Application no: H16-0272-15

Description: Proposed conversion of outbuildings to residential units

Location: WELLAND HOUSE
30 HIGH STREET
SPALDING
PE11 1UB

Amendment: Proposed refuge provided to bedroom
(Dwg. no. 15664-06 Rev A)

PROJECT Proposed Conversion to Outbuildings at 30 High Street Spalding	DRAWING Proposed Plan and Elevations. Roof Plan March 2015 drawing number : 15664-06 rev A
--	---

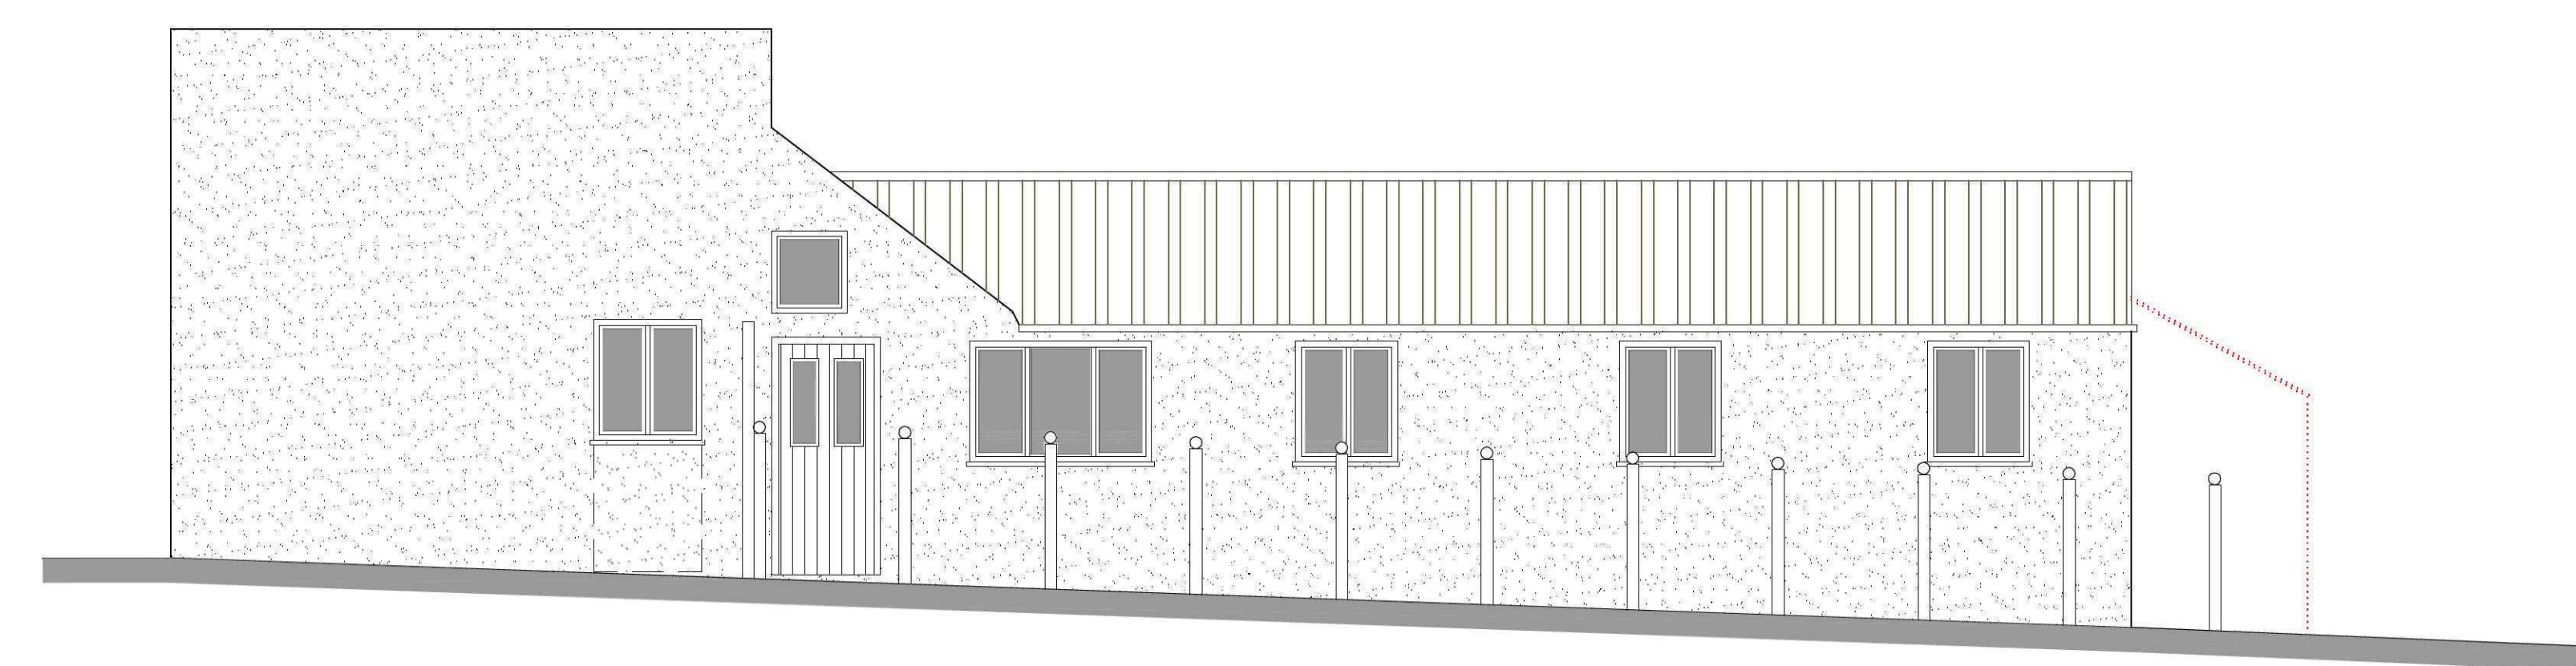
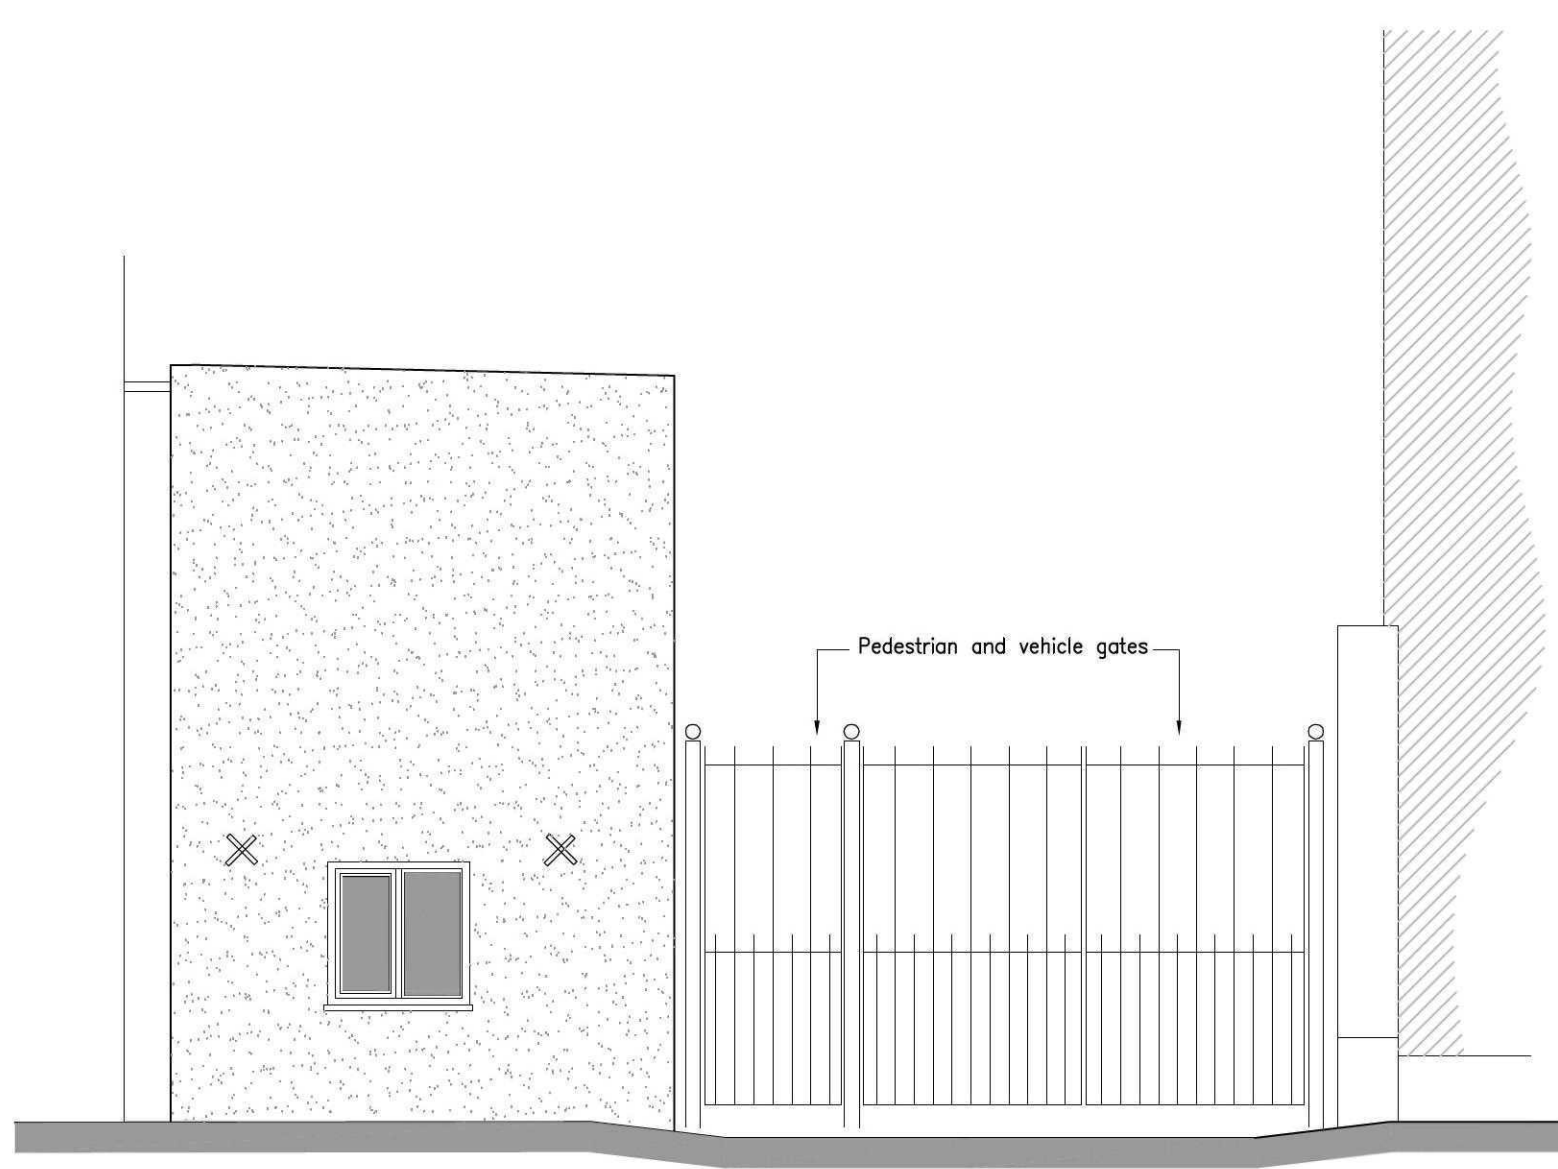
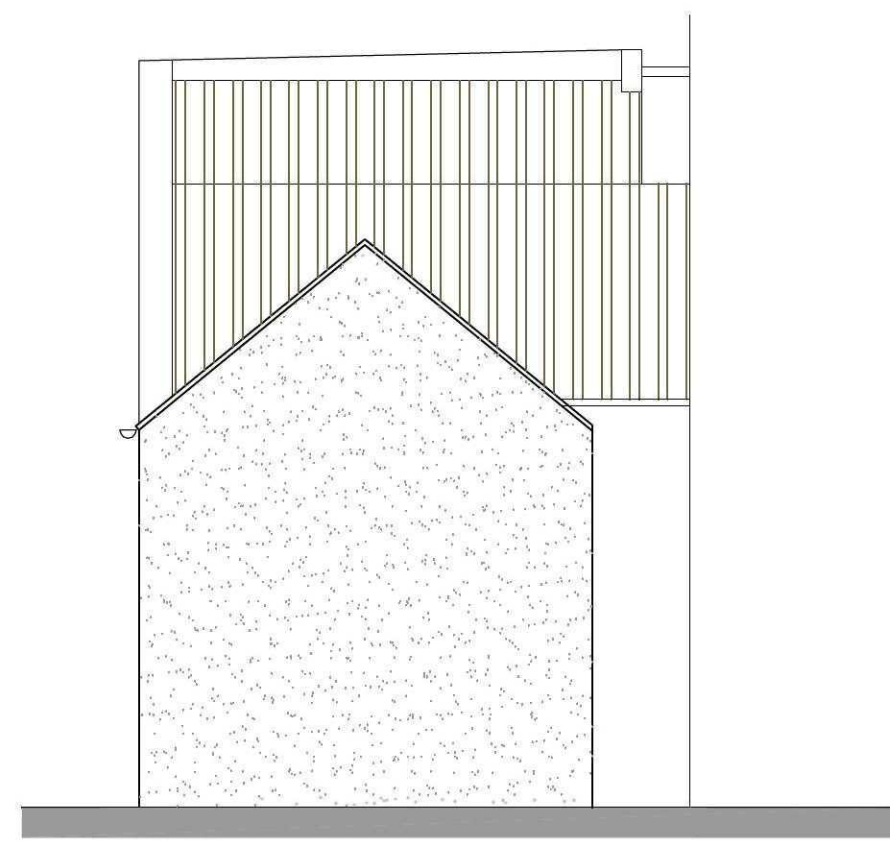
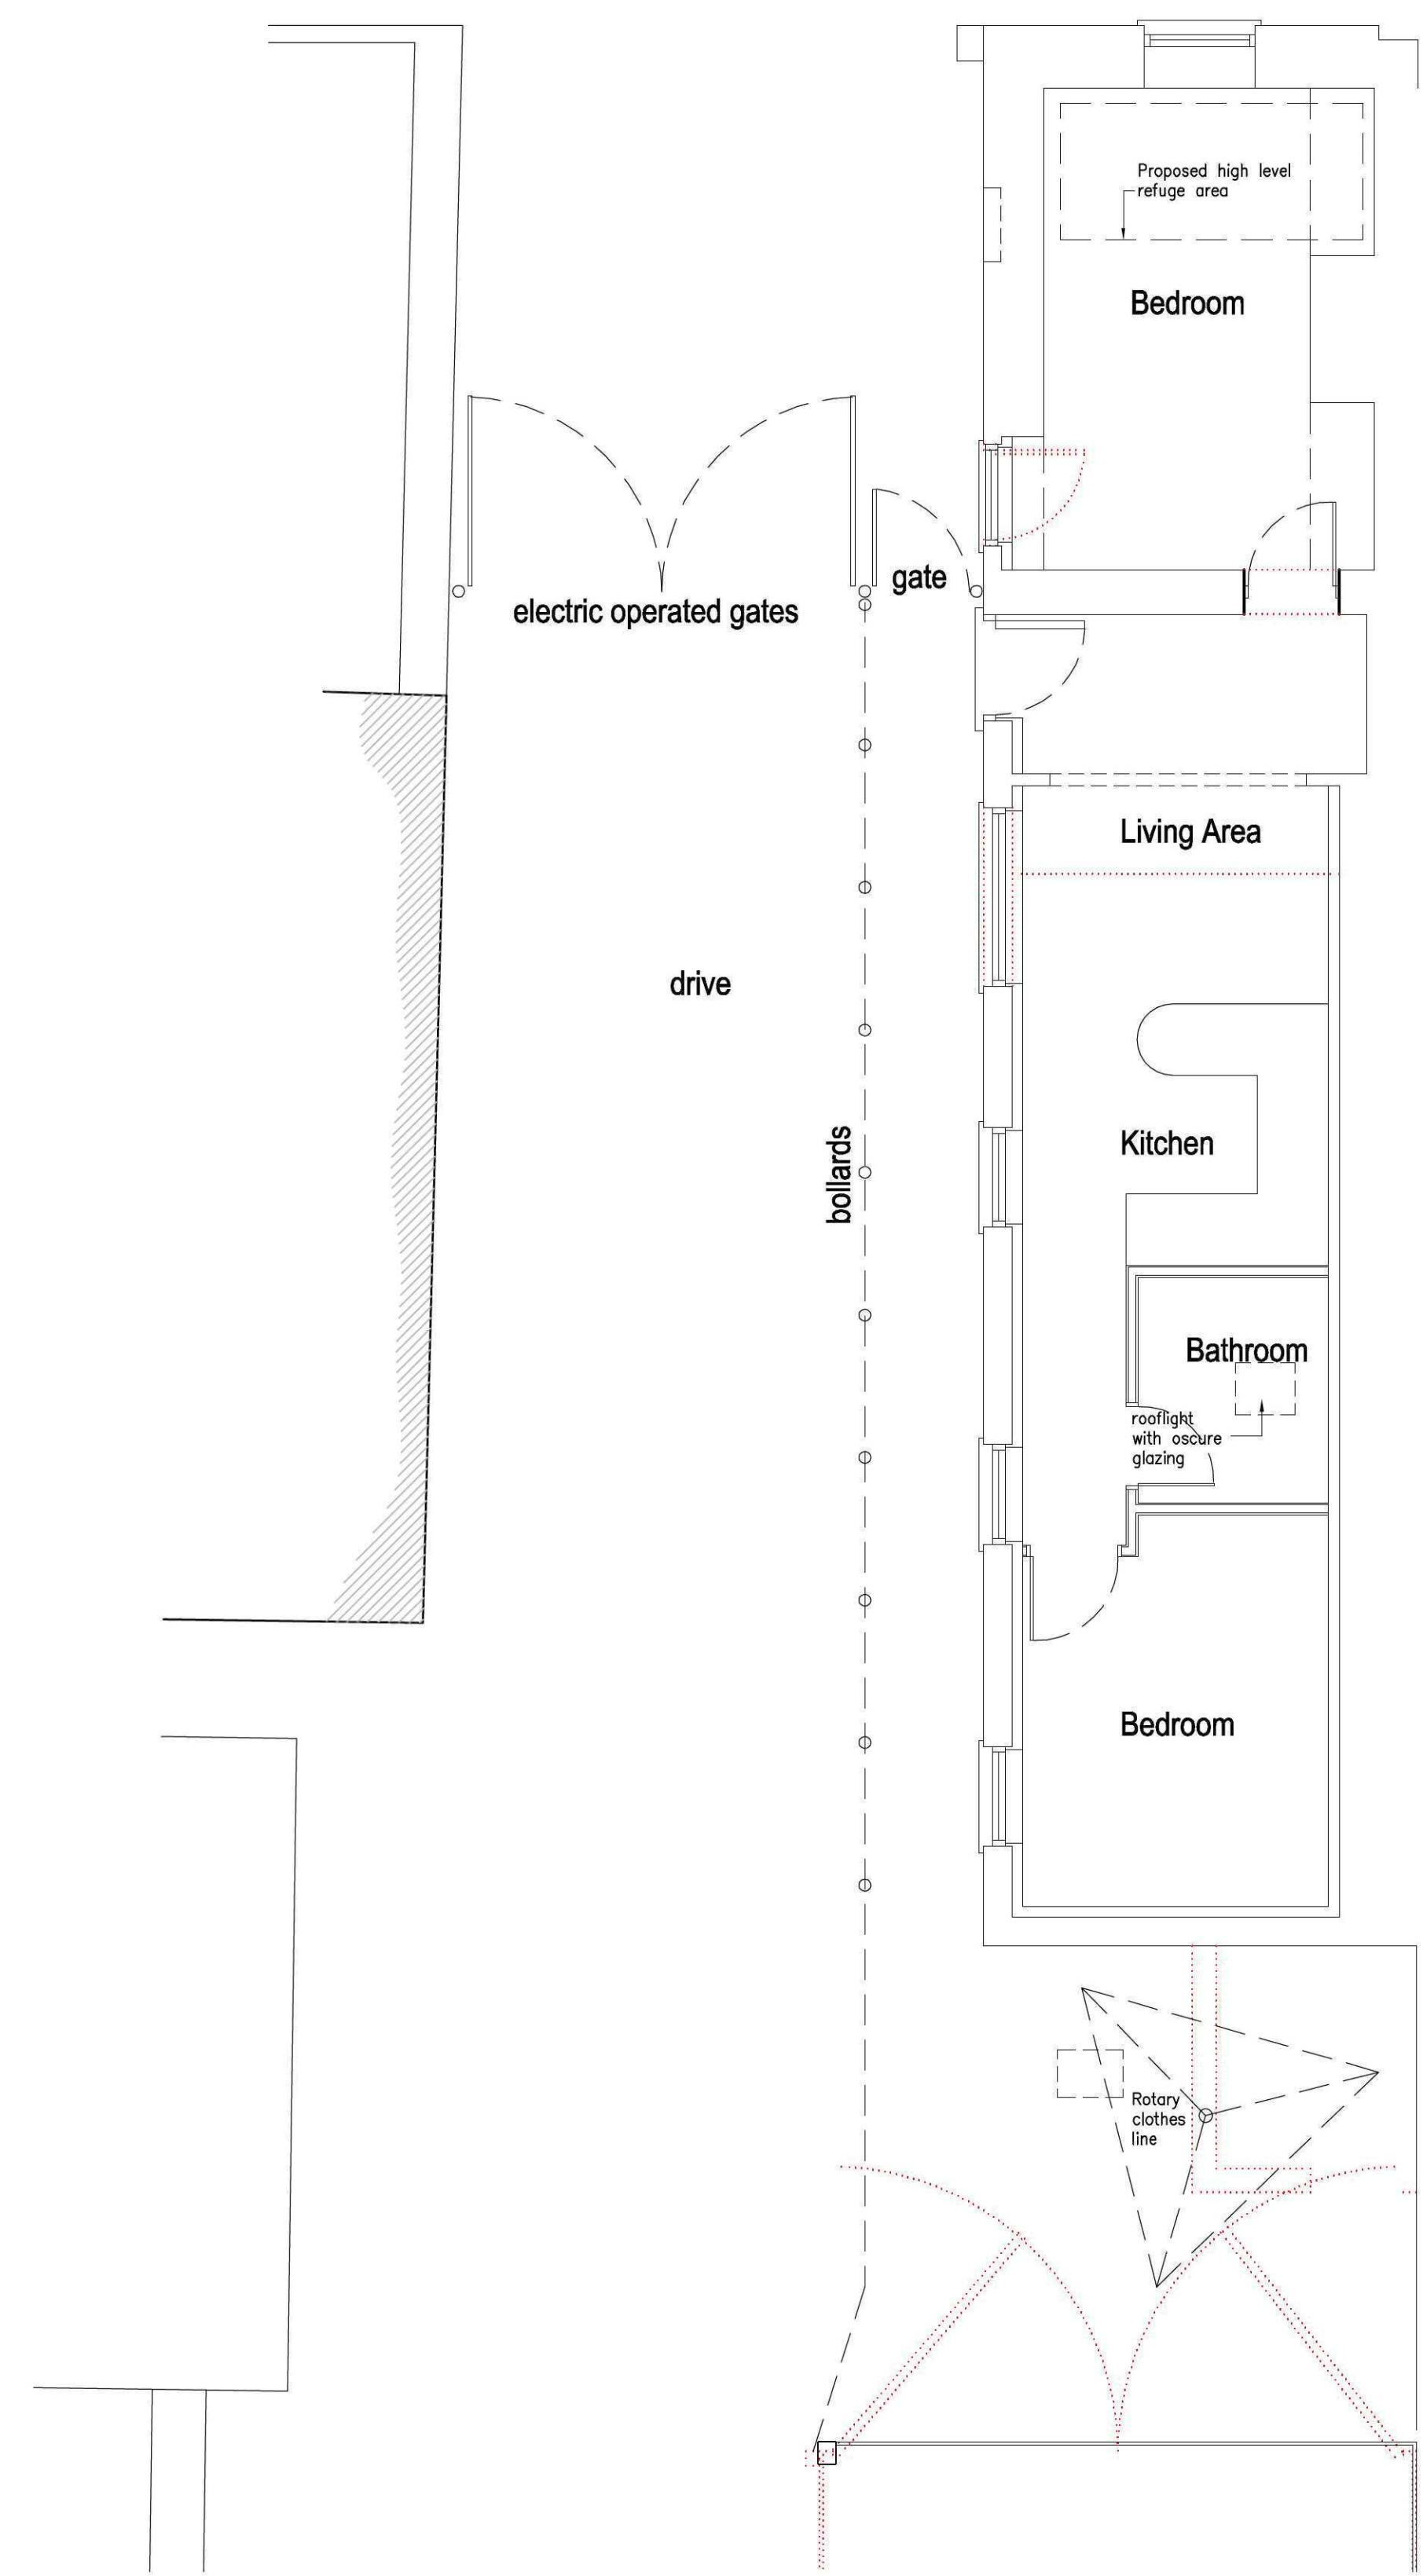
Further to discussion with Richard, please find attached amended drawing with a Refuge Area included to the front unit to appease the EA comment.
